Rezoning Transportation Analysis

Petition Number: 2022-137

Revision Log:

Date	Description
01-26-23	First Review (PDM)
02-22-23	Second Review (JP)

Plotted By: Watts, Austin Sheet: Set Shopton Rezoning - Layout-RZ-1 TECHNICAL DATA SHEET March 20, 2023 06:28:13pm K:\CHL\PRJ\015272_AAC\048 Shopton Road Industrial\02 - DWG\PlanSheets\Rezoning\RZ-1 TECHNICAL DATA SHEET.dwg

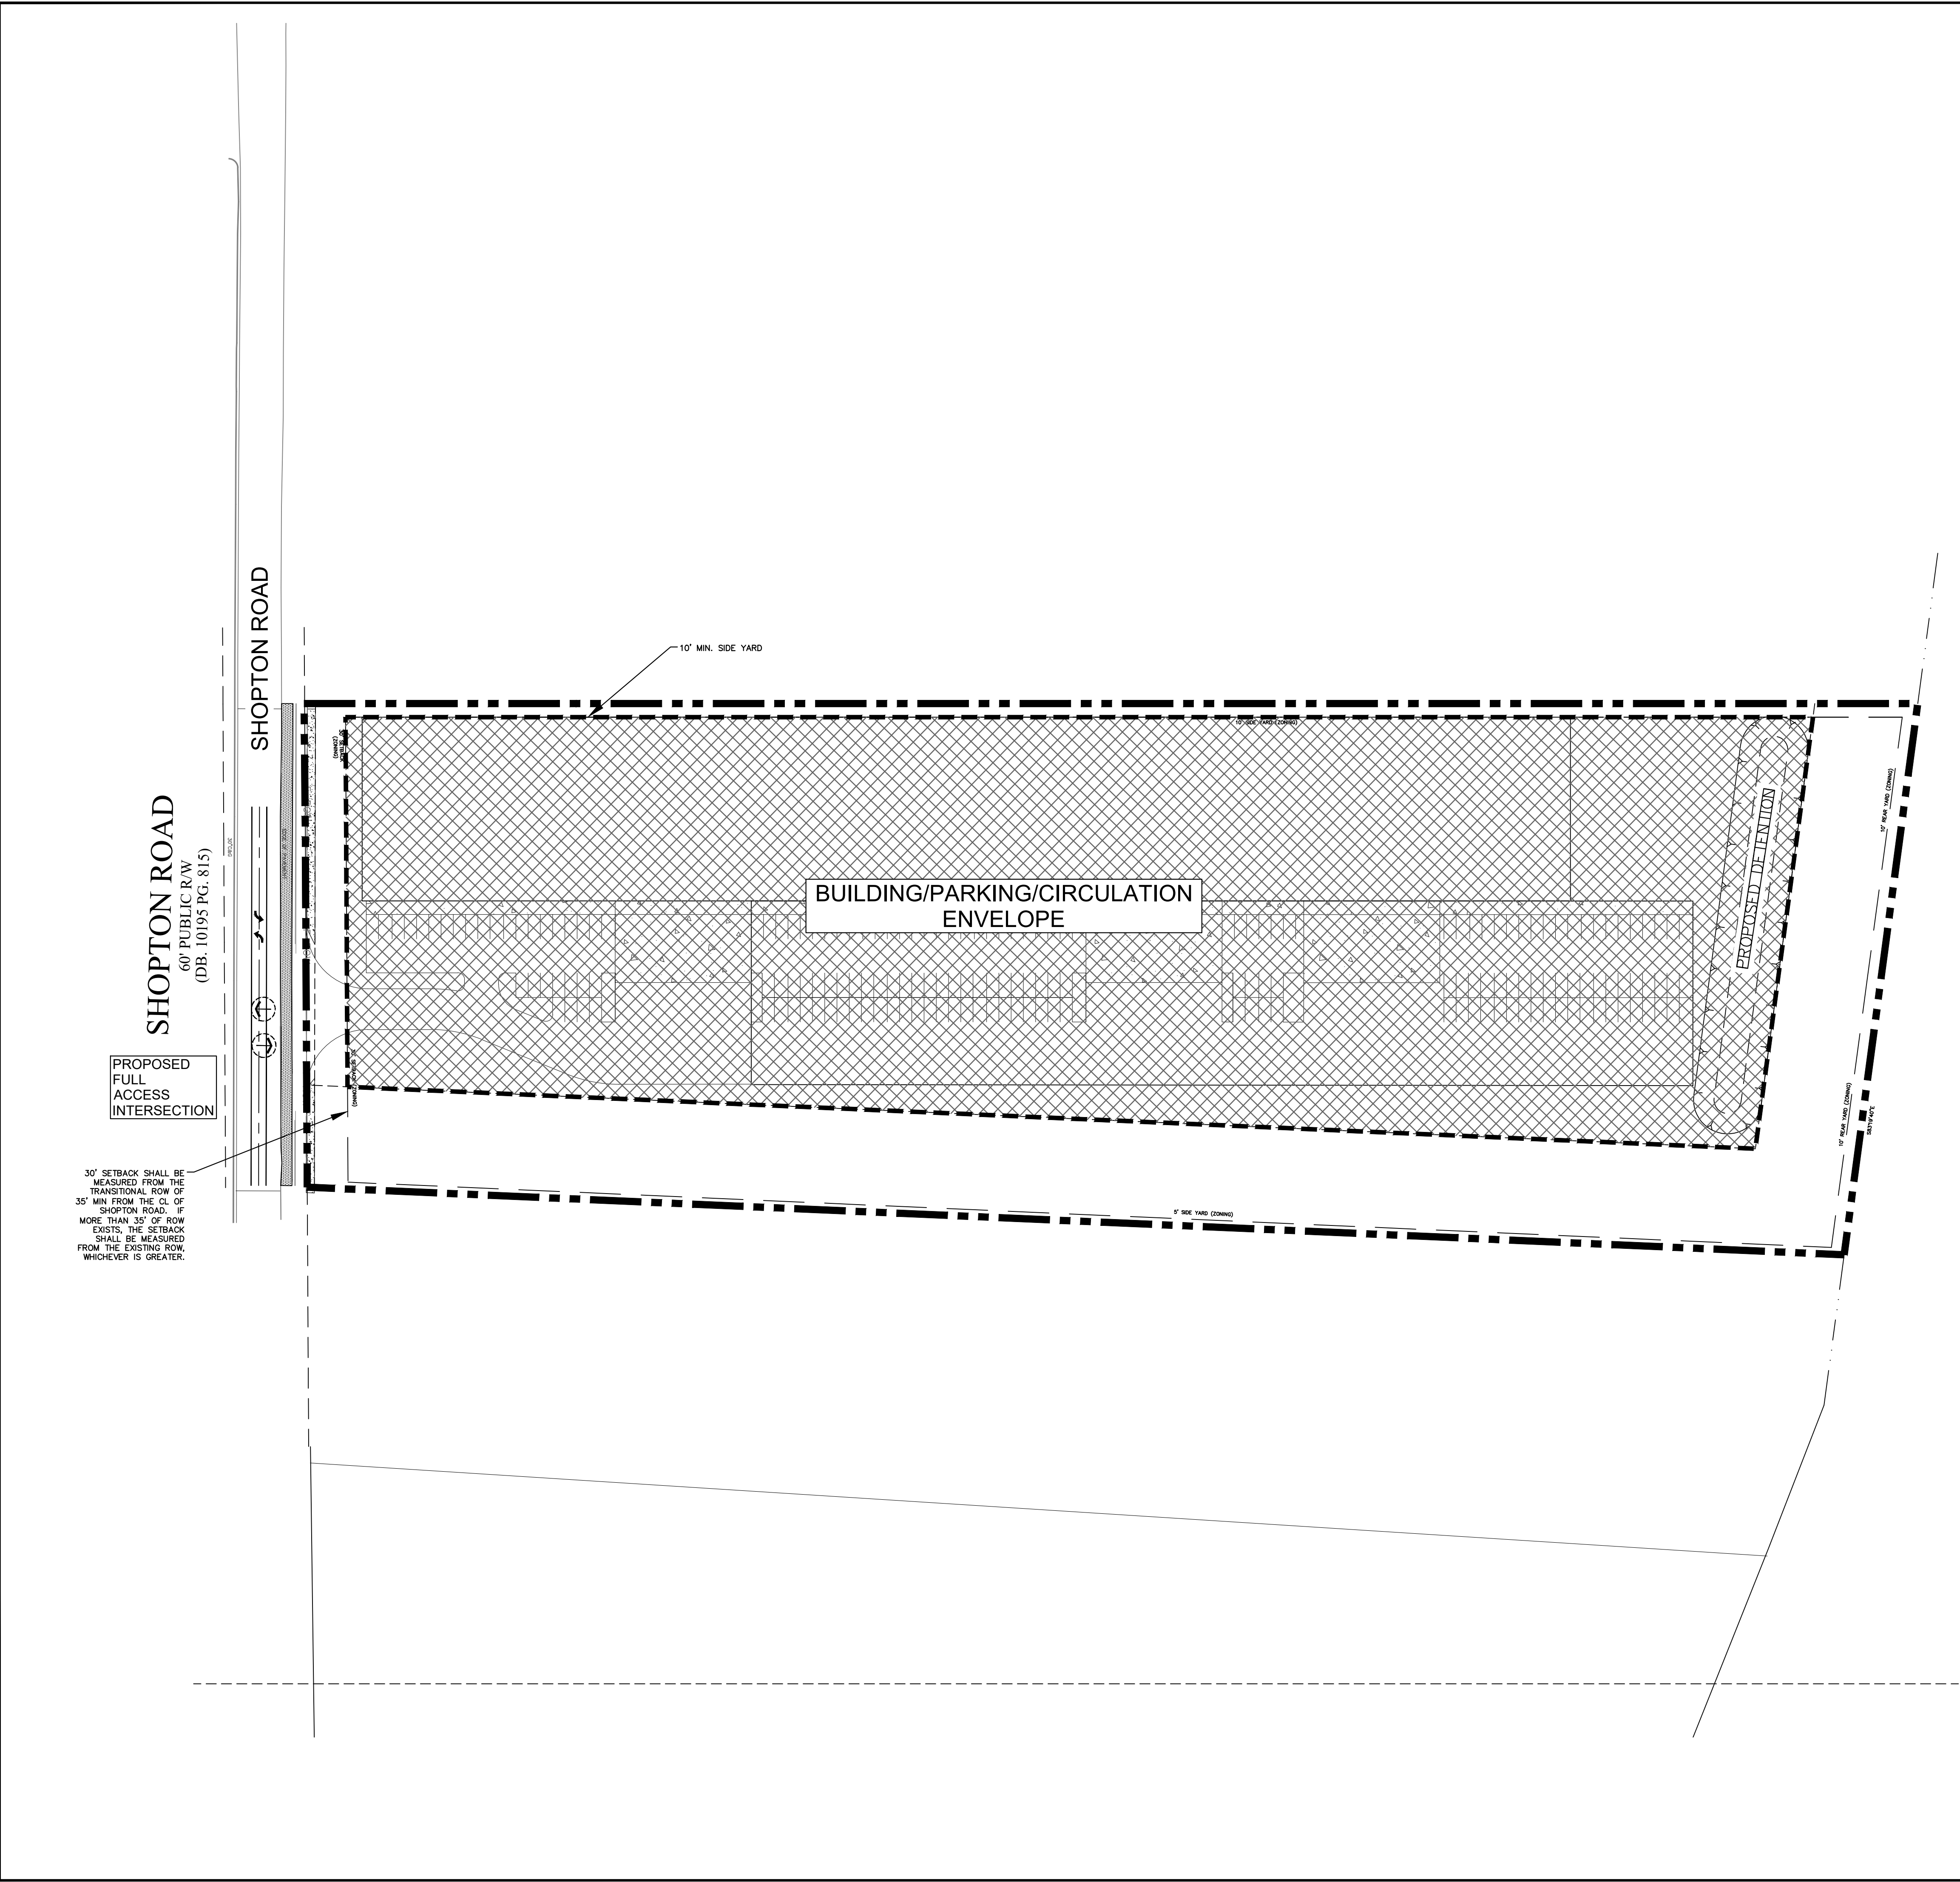
- a. **Shopton Road:** Location of curb and gutter to be moved to 27 feet from roadway centerline to accommodate the Charlotte Streets Map with a roadway typical section of a two plus lane avenue with buffered bike lanes.

Label and dimension the curb and gutter from the centerline for each road on the site plan.

5. Revise site plan and conditional note(s) to commit to construct an 8-foot planting strip, and 8-foot sidewalk on Shopton Road per Chapter 19. The site plan shall label and dimension both items from the back of curb and gutter or edge of pavement. The wider sidewalk also meets the Charlotte WALKS Policy.

Clarifying Comment from 2-22-23: Site plan is showing 8' and 6', streets map calls for 8' and 8', please revise to provide an 8' sidewalk

6. Site is to remain in the ETJ: Revise site plan and conditional note(s) to construct 8-foot planting strips and 8-foot sidewalks on Shopton Road. The site plan shall label and dimension both items from the back of curb and gutter or edge of pavement. Add conditional note: The entire facility must be outside of the right of way and within a public access easement. Add conditional note committing to construction and maintenance of the 8-foot sidewalk on Shopton Road.
